## Summary of comments made by Biofuelwatch at ISH3

Summary of comments made by Biofuelwatch at ISH4

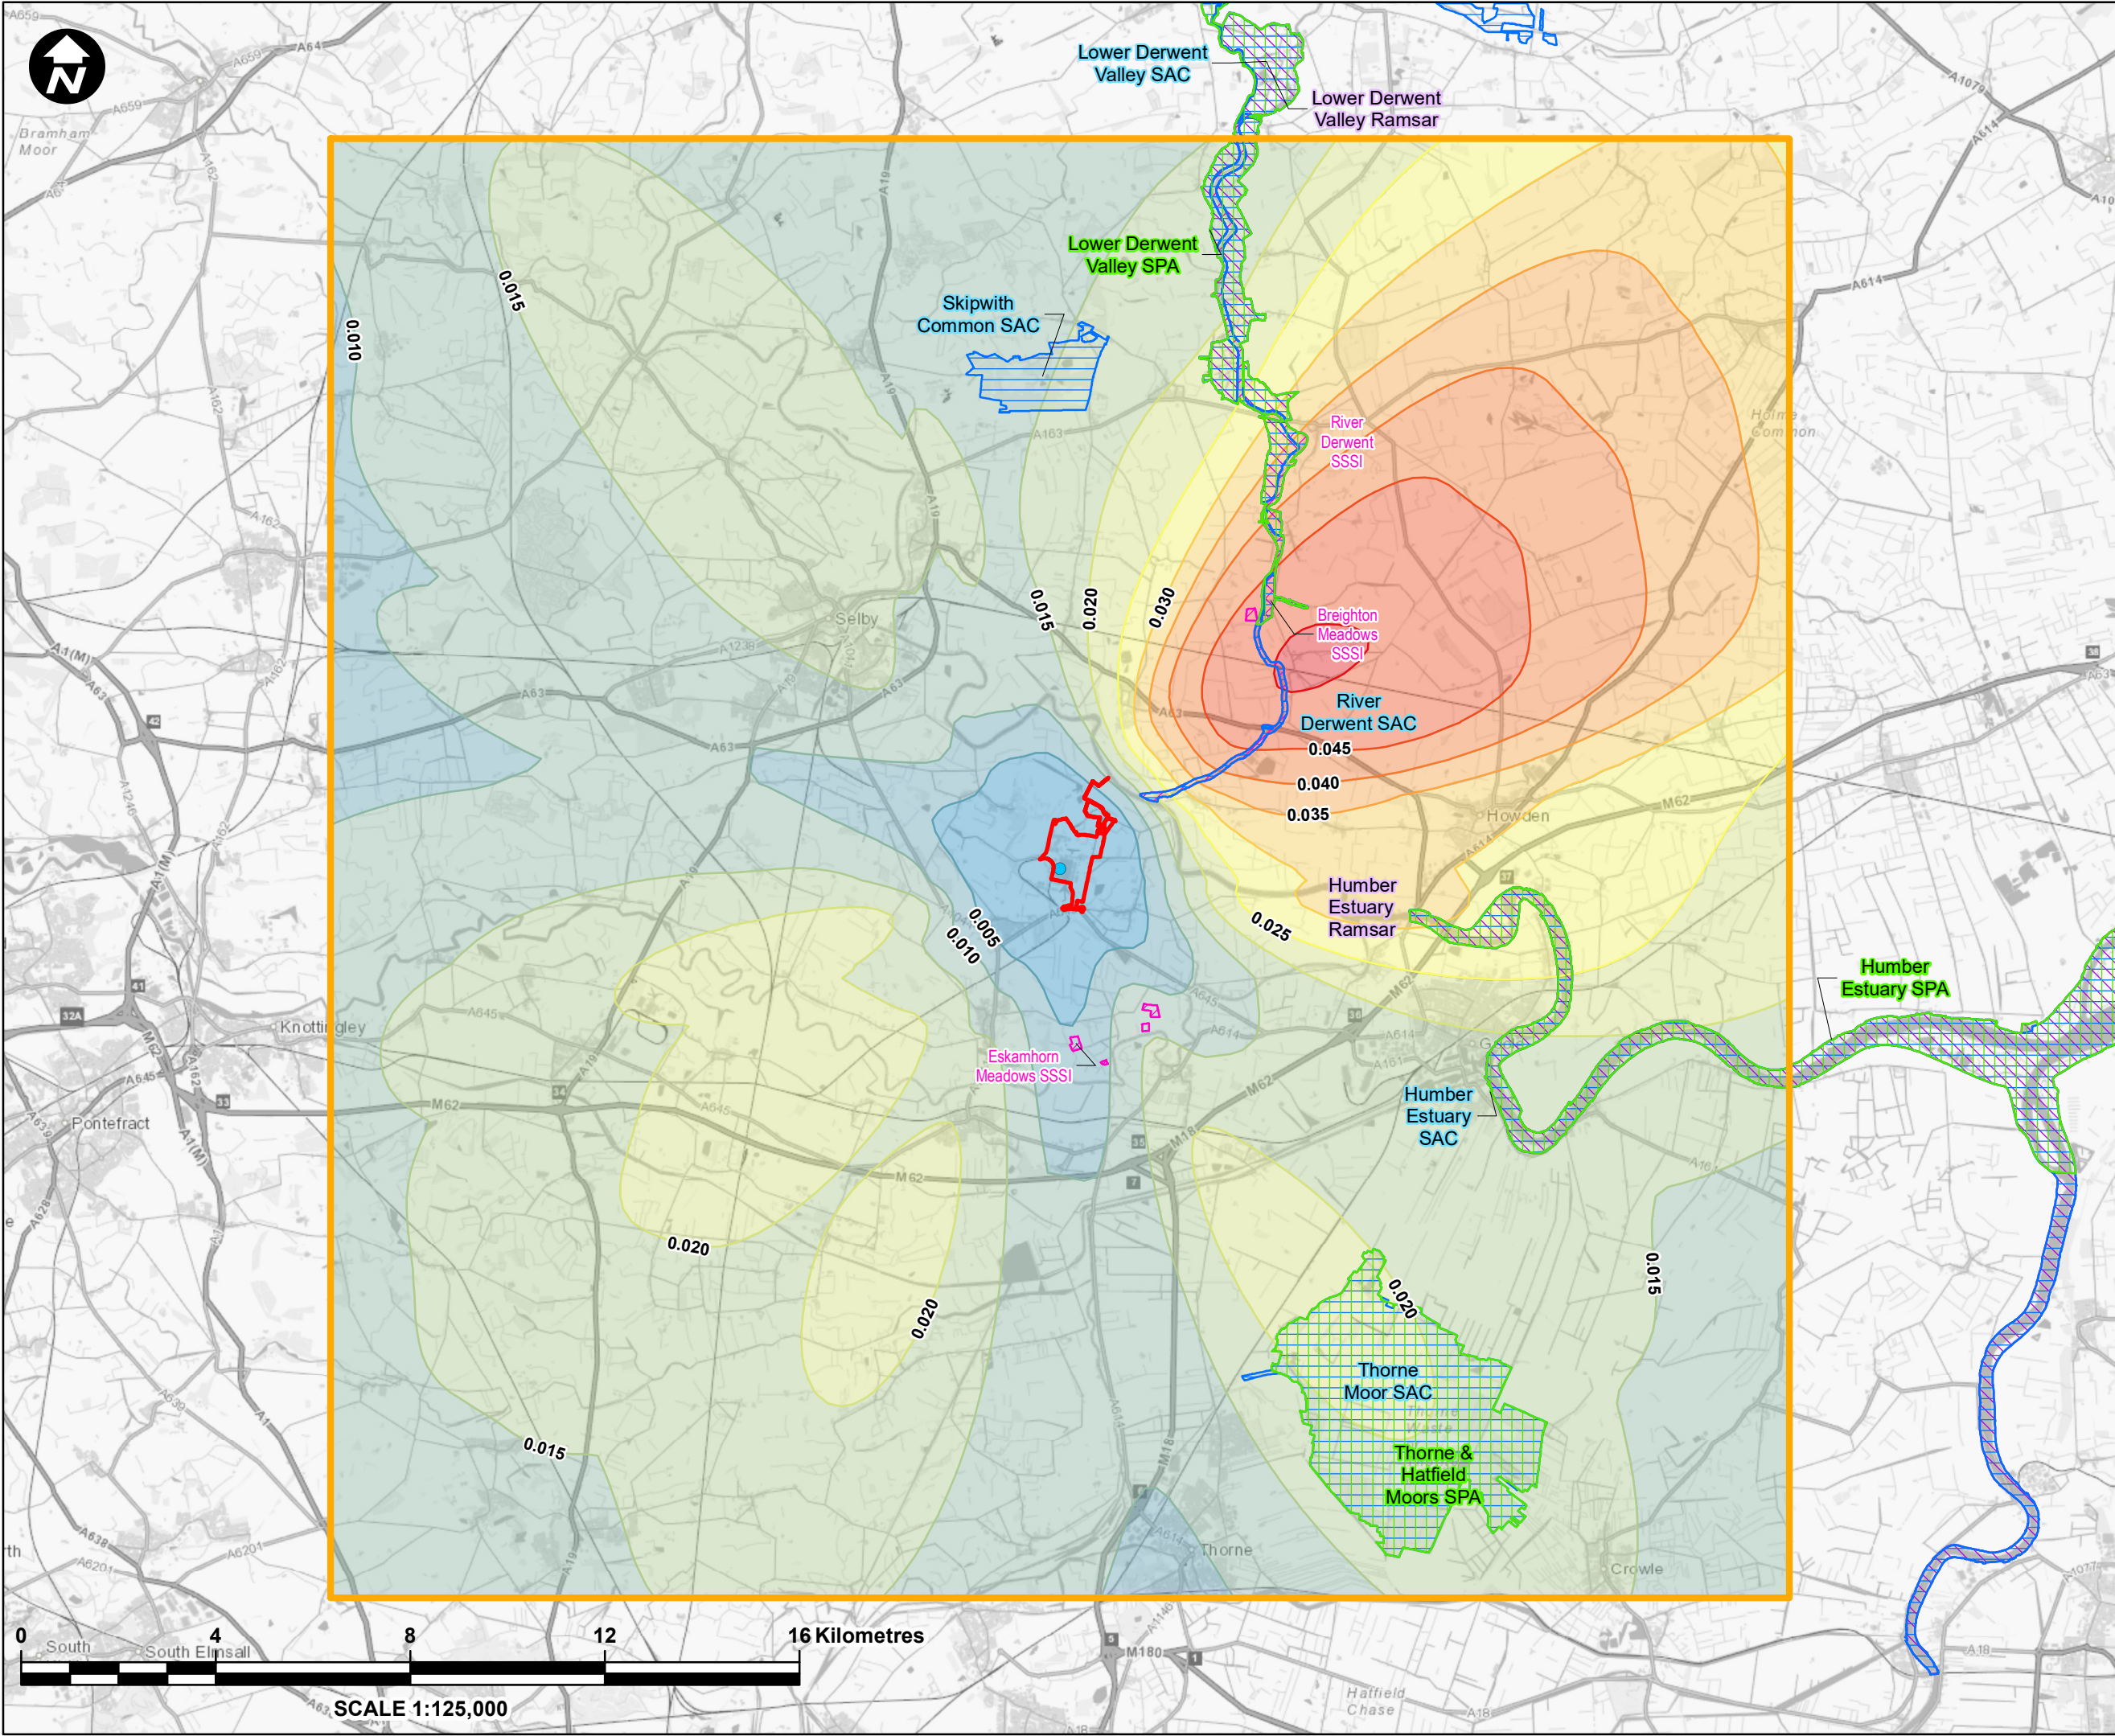
We're concerned that there's no mention of uncertainty in the modelling, so we'd like to ask Natural England to consider this. The current modelling already predicts loads that exceed critical loads (e.g. the critical load for nitrogen is exceeded at Thorne Moor which supports breeding nightjars) yet there's no mention of uncertainty. There's an acknowledgement that there already is uncertainty so the potential impacts of those uncertainties should be considered and that's something we'd like Natural England to ask the applicant.
